Subject: 3/2014/1109

From Bowland Forest higher division parish council

Following the parish council meeting last night the council would like to submit the following observations:

PROPOSED ELEVATIONS

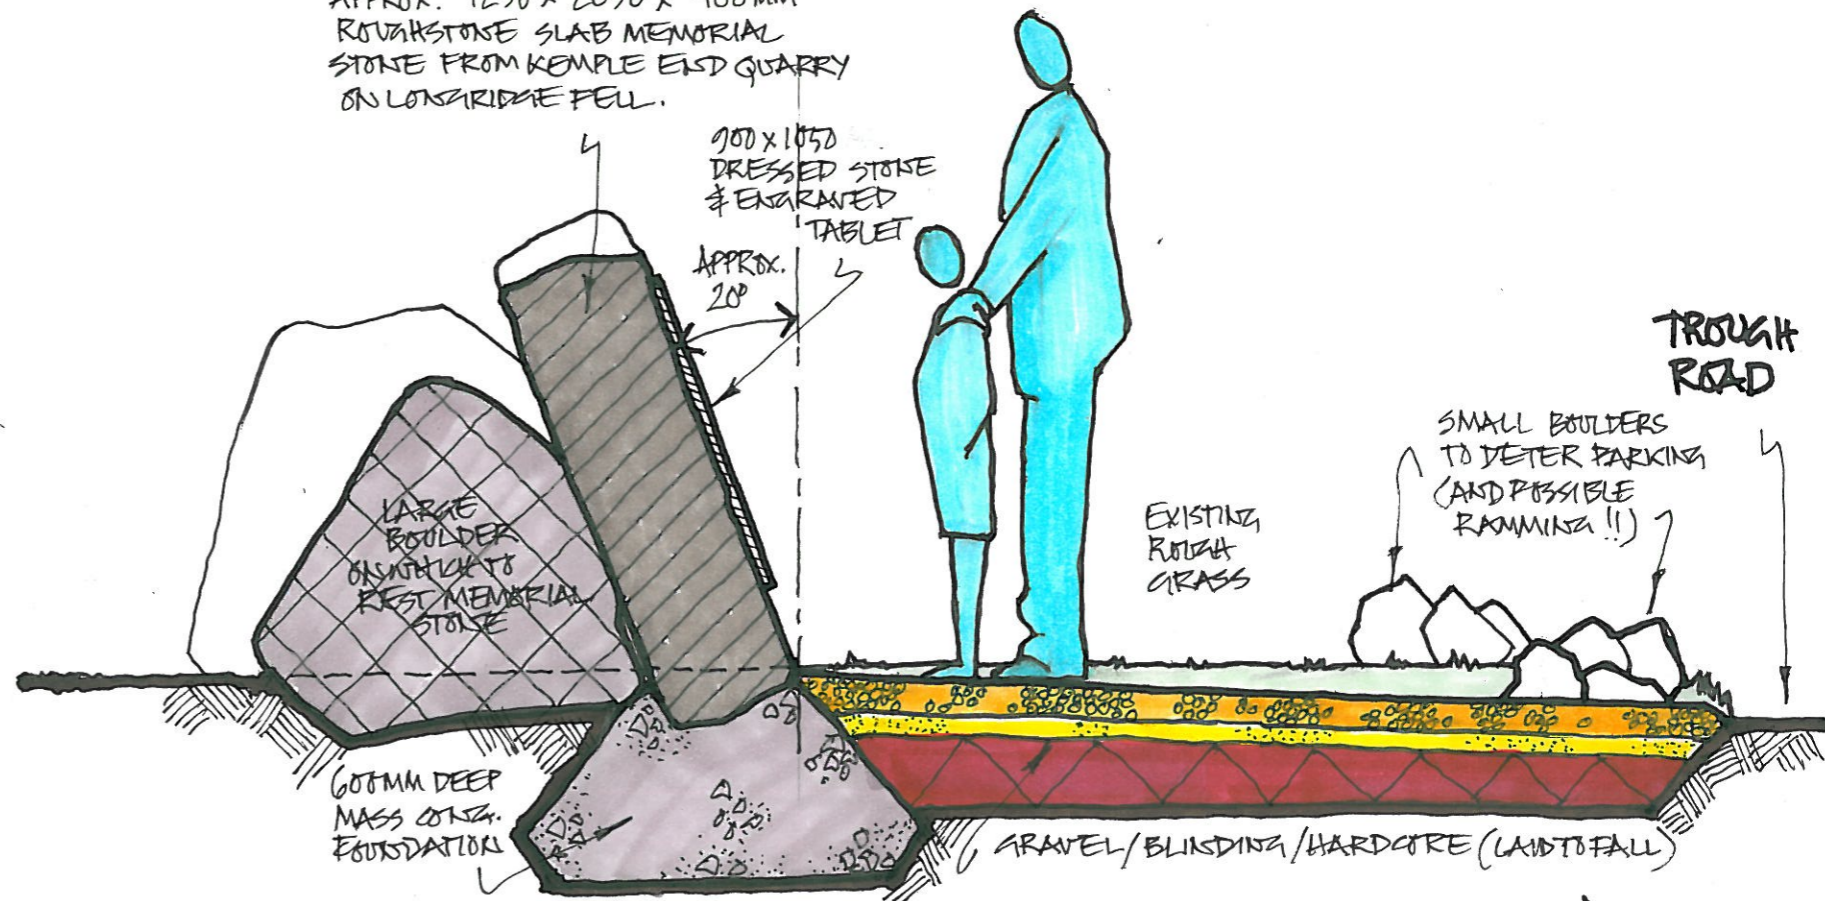
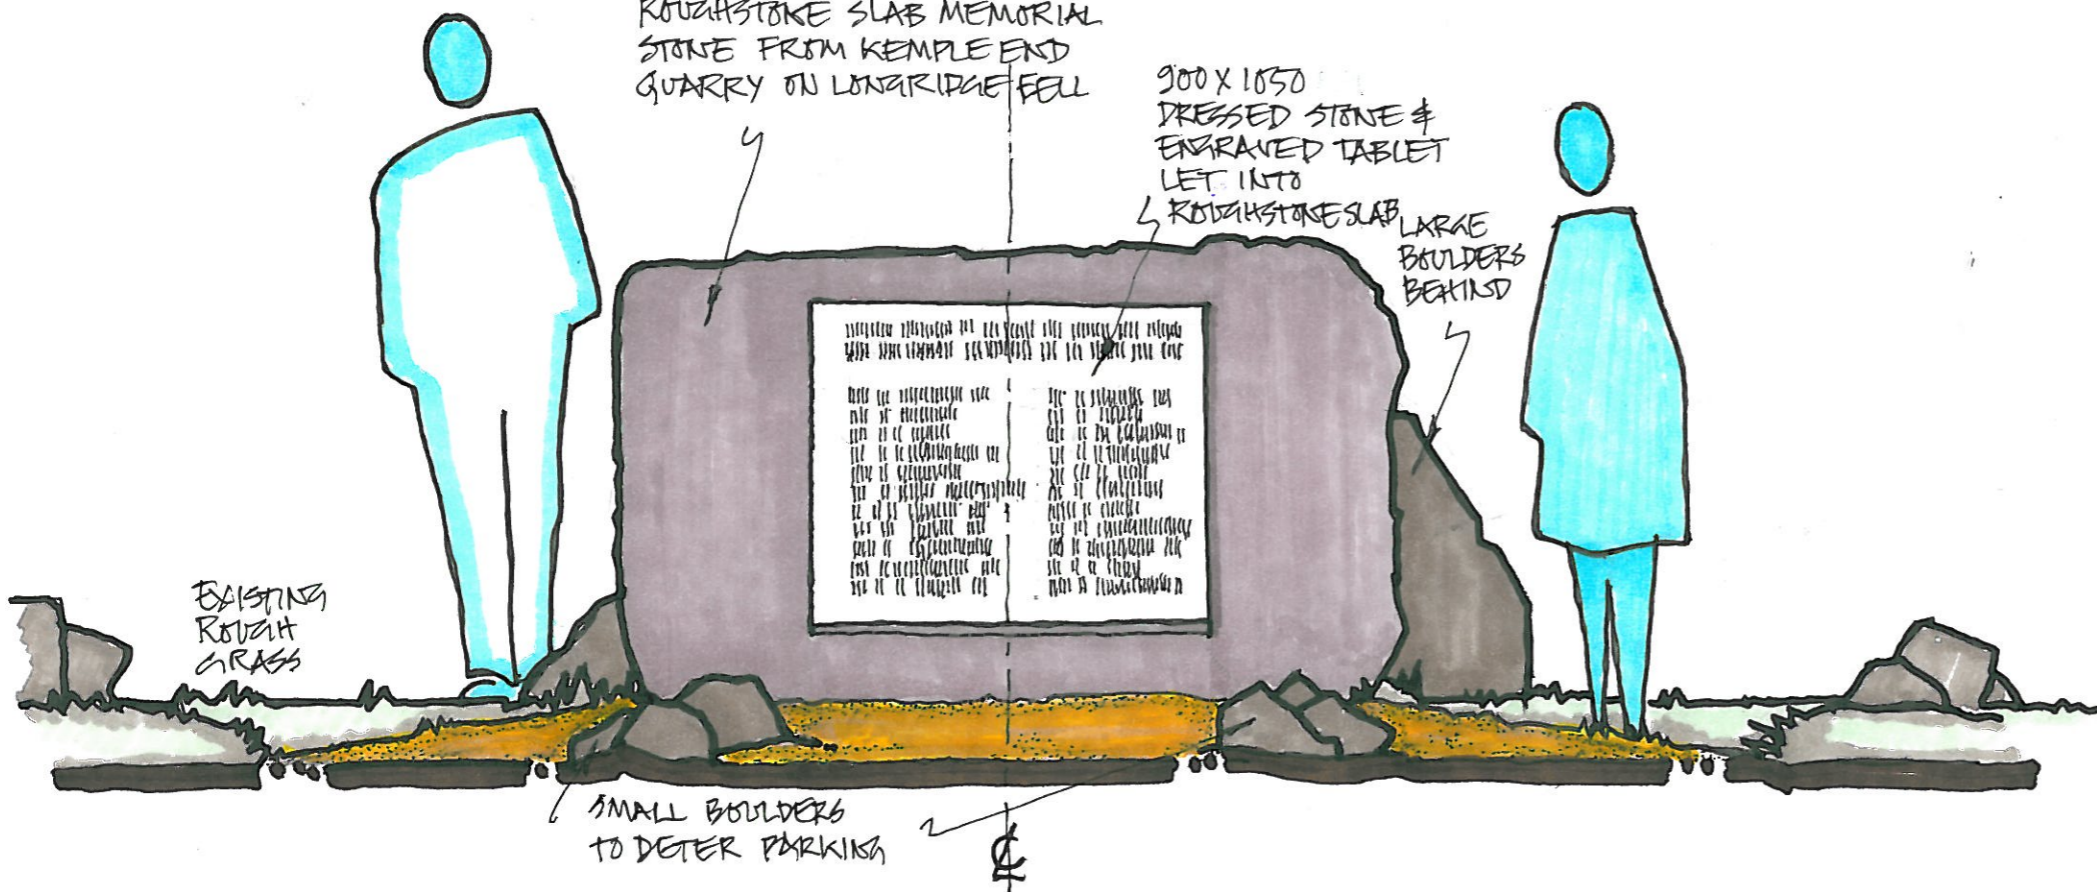
1. Could the status of the land be confirmed to the parish council please - is it owned by United Utilities and common land? The parish council is anxious that the land remains as common land. At a meeting in 1982 it was accepted by NWWA as common land.
2. Should the AONB be contacted about this issue if it hasn't already been consulted?
3. The parish council would like confirmation of who will maintain the monument in future - the parish council does not want responsibility for it.
4. There were questions about the positioning of the monument and whether it is in the best position.
